Elite Nugen
The White Lodge
Rectory Lane
Angmering
BN16 4JU

Please ask for: Ms Iqraa Malik
Email: iqraa.malik@terraquest.co.uk
Telephone: 0121 234 1390
Our Ref: A/230/21/L
Your Ref:
Date: 4th November 2021

Listed Building Consent for Alterations, Extension or Demolition of a Listed Building

Development: Erection of two storey side extension. (This application may affect the character and appearance of the Angmering Conservation Area)
Location: The White Lodge Rectory Lane Angmering BN16 4JU

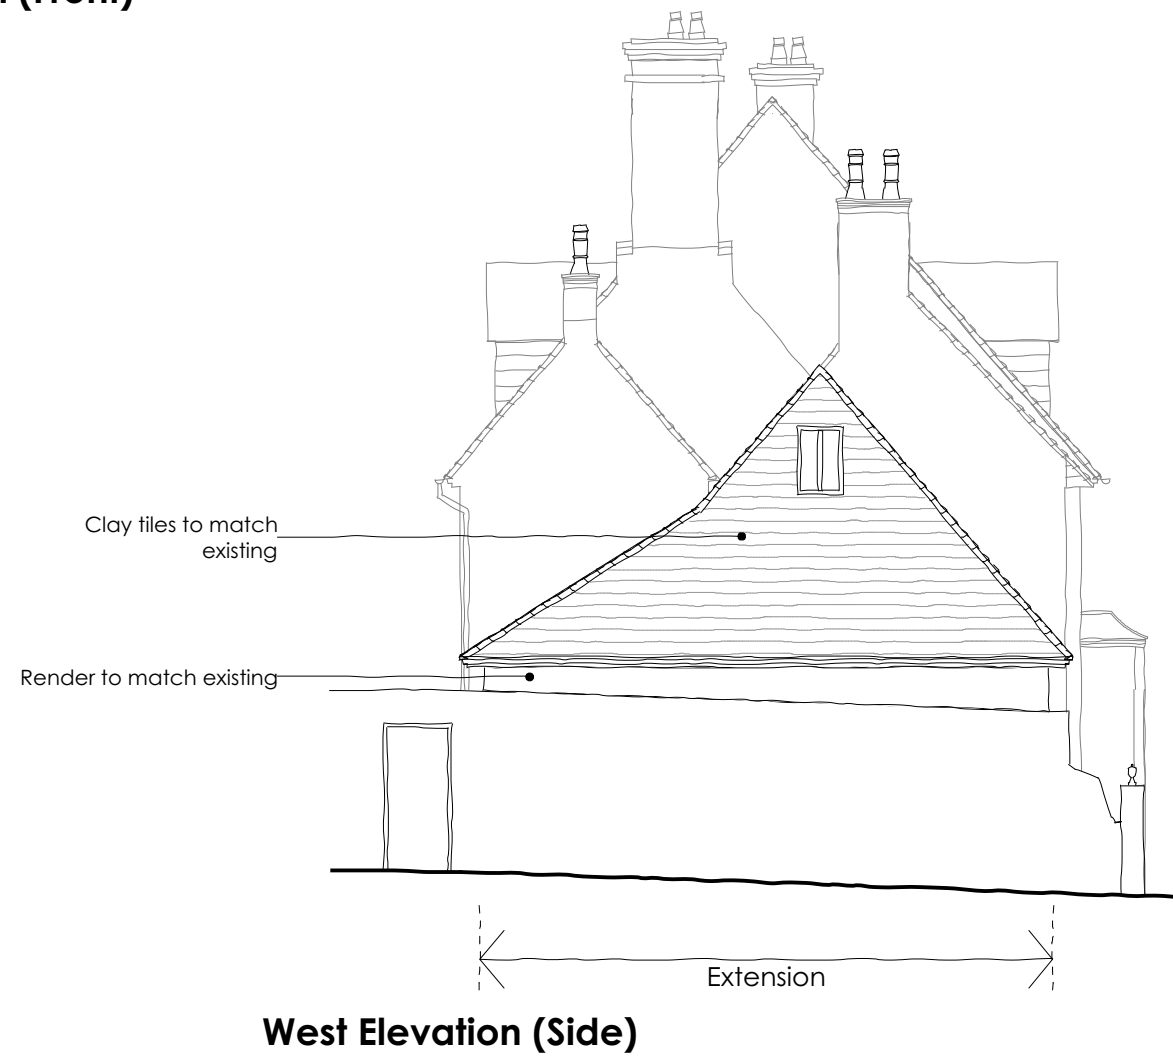
The windows are inconsistent between the existing/proposed first floor plan and existing/proposed

rear elevation. Please review and amend.

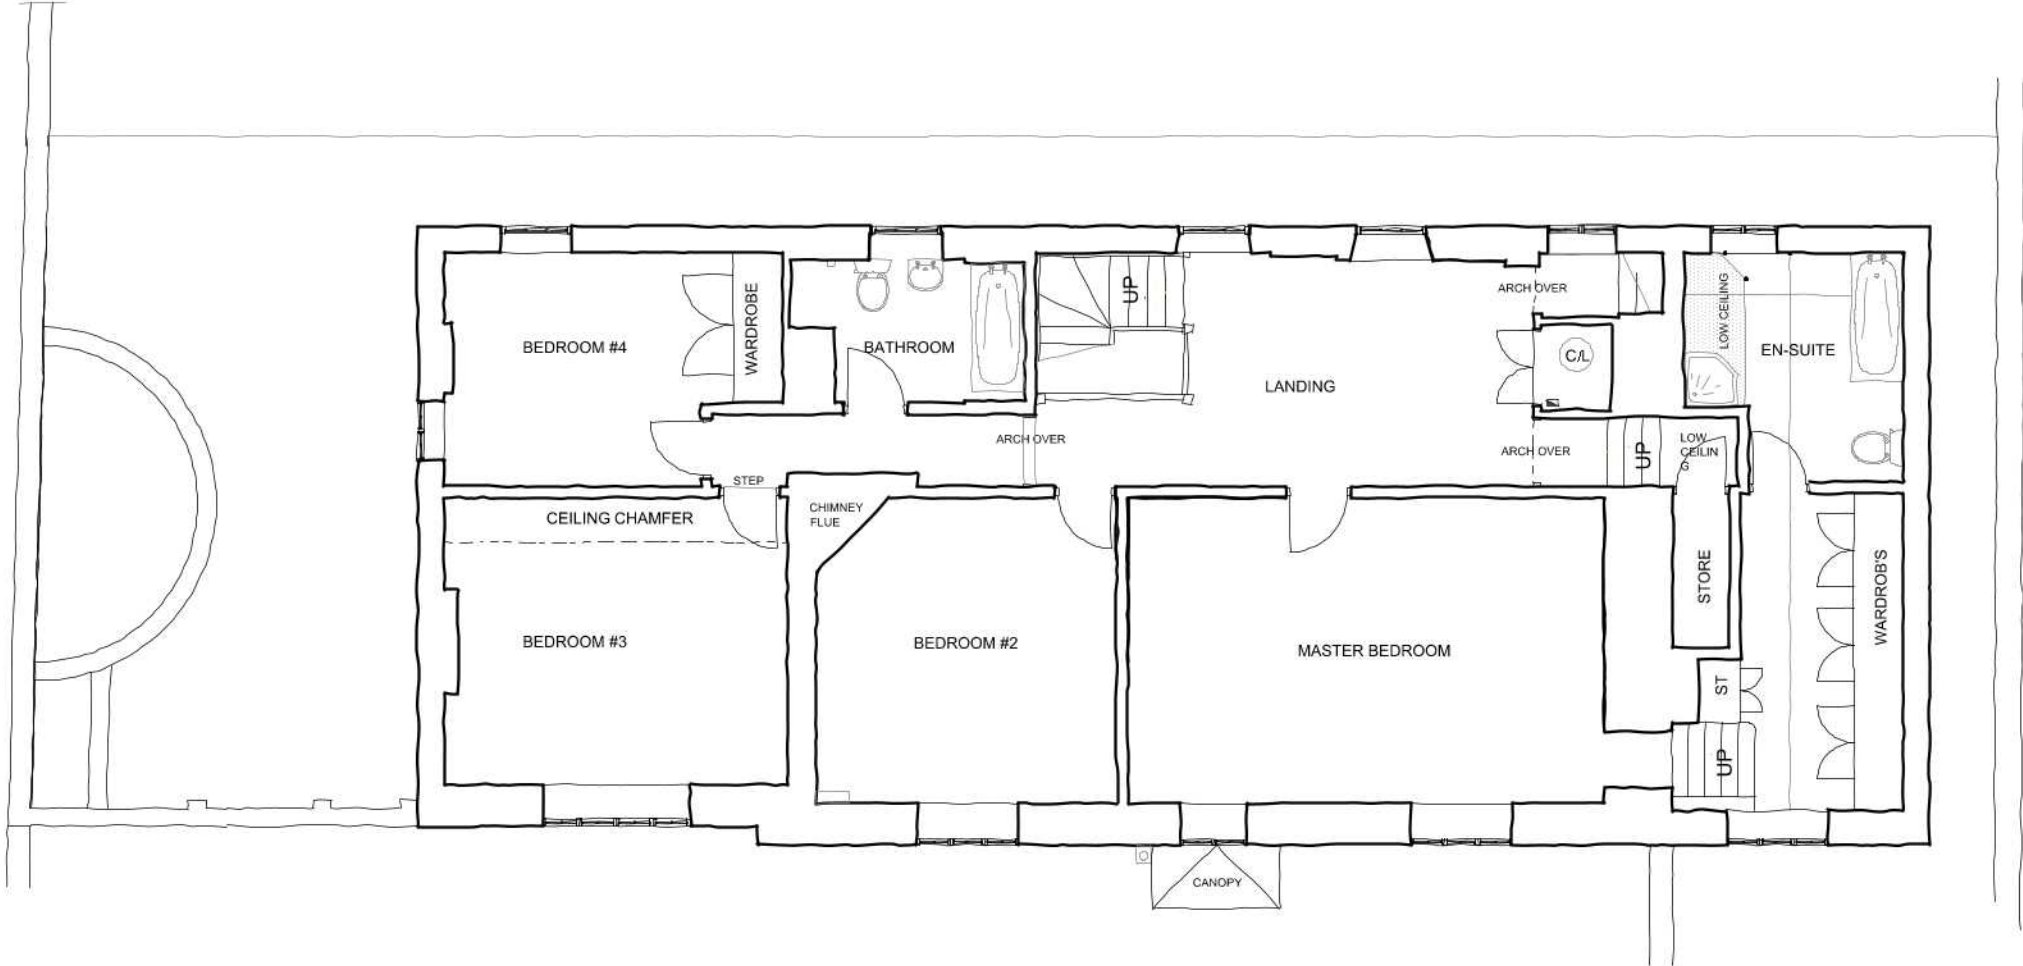
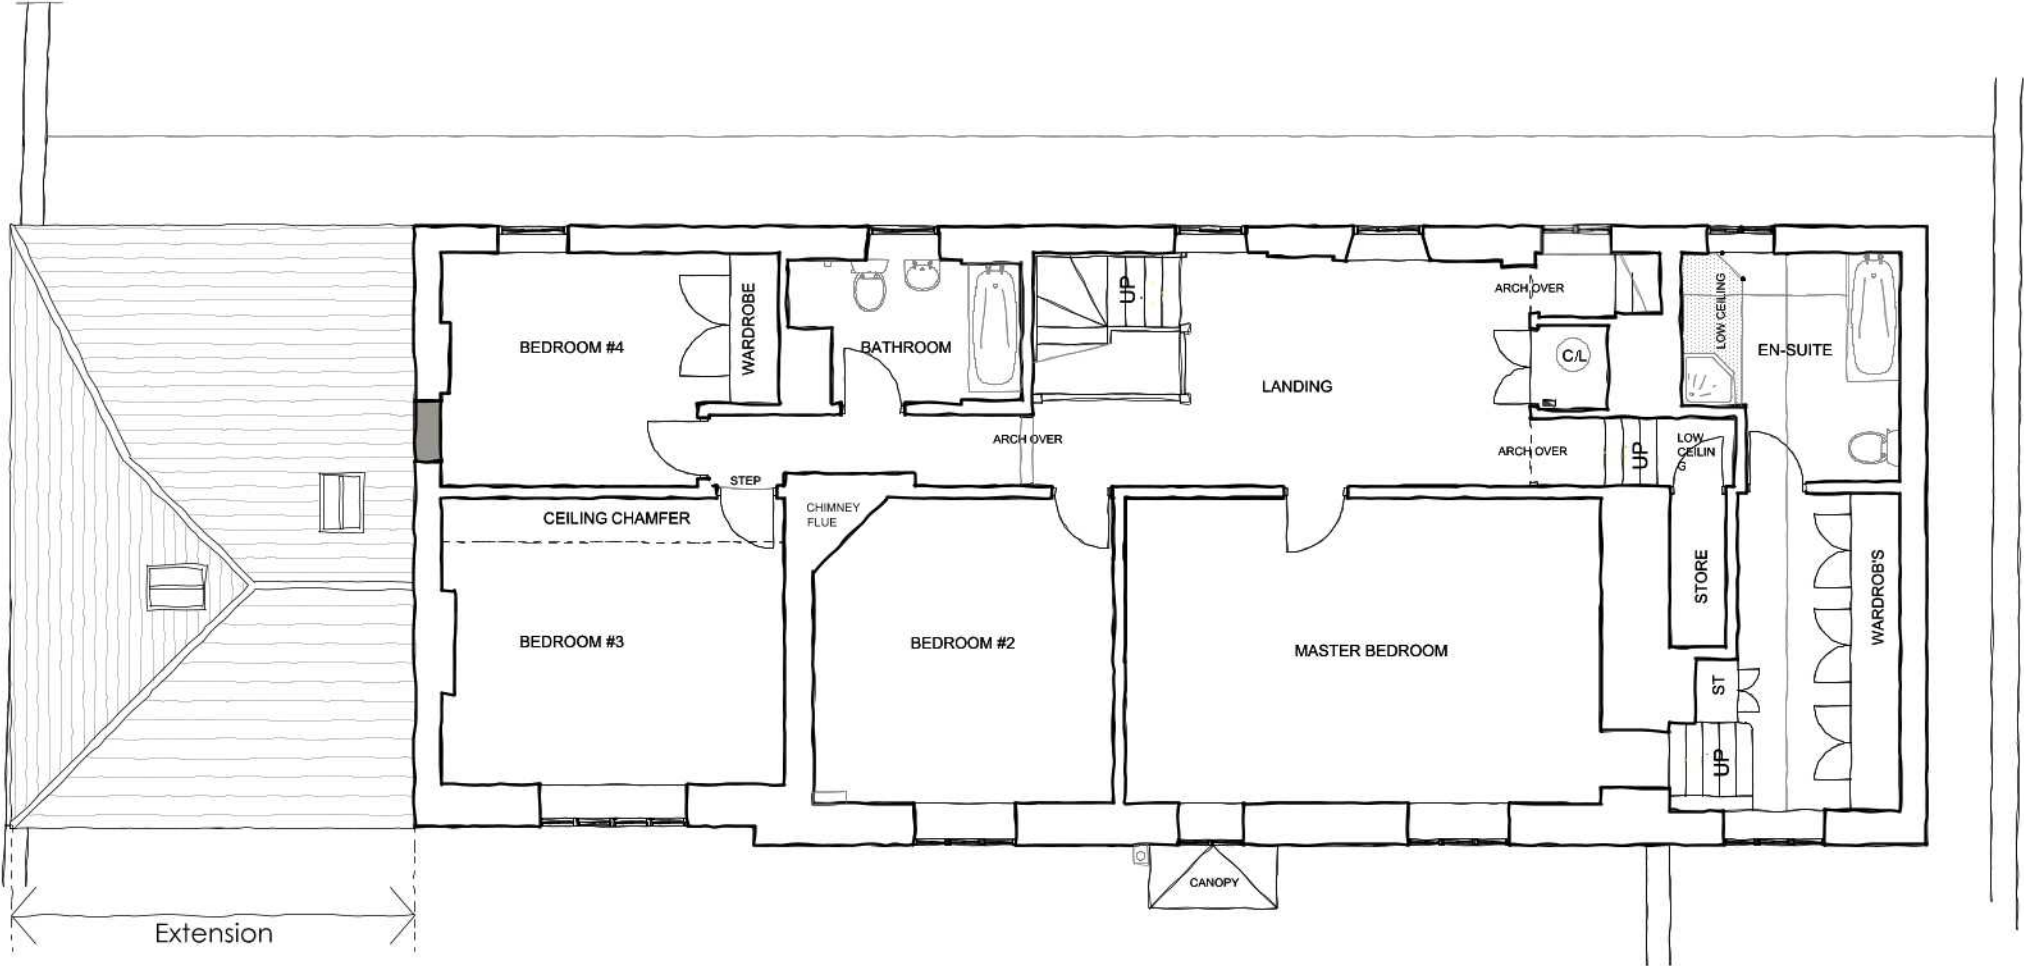
Existing/Proposed Plans
